Office of
Environment
& Heritage

RE: Sandigo Solar Project (SSD 8872) – Exhibition of Environmental Impact Statement

ATTACHMENT A – OEH Assessment Summary for Sandigo Solar Project Environmental Impact Statement (SSD 8872)

Figure 5: Vegetation Zones within the development site, scattered paddock trees and location of Plot surveys

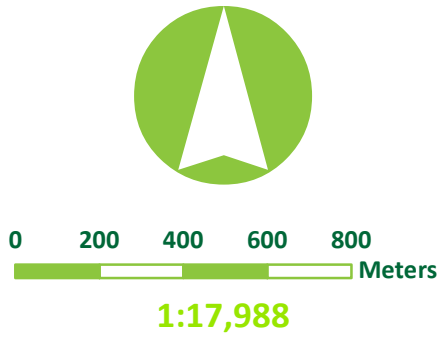
The vegetation zones described in Section 2.1 do not match the zones mapped in Figure 5.

- The use of the term 'plot/transect' is ambiguous. BAM plots for vegetation measurements do not include transect sampling and should be as per BAM sections 5.2.1.7 to 5.2.1.11.
- The number of plots undertaken within the development footprint is unclear. The text states that seven plots were sampled within the development site, however Table 2.1 shows 14 plots within the two zones.
- Table 2.1 (page 14) refers to Zone 2 as 'PCT 76 (low condition)' and based on the small area is presumably the buffered paddock trees. The description and mapped area of Zone 2 on Figure 5 (page 68) does not match Table 2.1.

- Zone 1 is cropping with scattered trees.
 - Survey results for 'Zone 2- grazed' indicate that the understorey is predominantly non-native.
 - Based on vegetation zones mapped on Figure 5 (BDAR page 68), the paddock tree zone would include both zones 1 and 2.

OEH recommend that the vegetation zone assessment is revised and the credit requirement re-calculated following discussions with OEH South West Branch. The following steps are likely to need re-assessment:

- *Assignment of all native vegetation on the site to a vegetation zone.*
- *Inclusion in Table 4.3 of all trees able to be assessed using the paddock tree assessment module.*
- *Assessment of all class 2 and 3 paddock trees for threatened species habitat suitability*
- *Re-calculation of the offset requirement using the streamlined assessment module for clearing paddock trees (BAM Appendix 1).*
- *Impact summary in BDAR Section 6.4.*
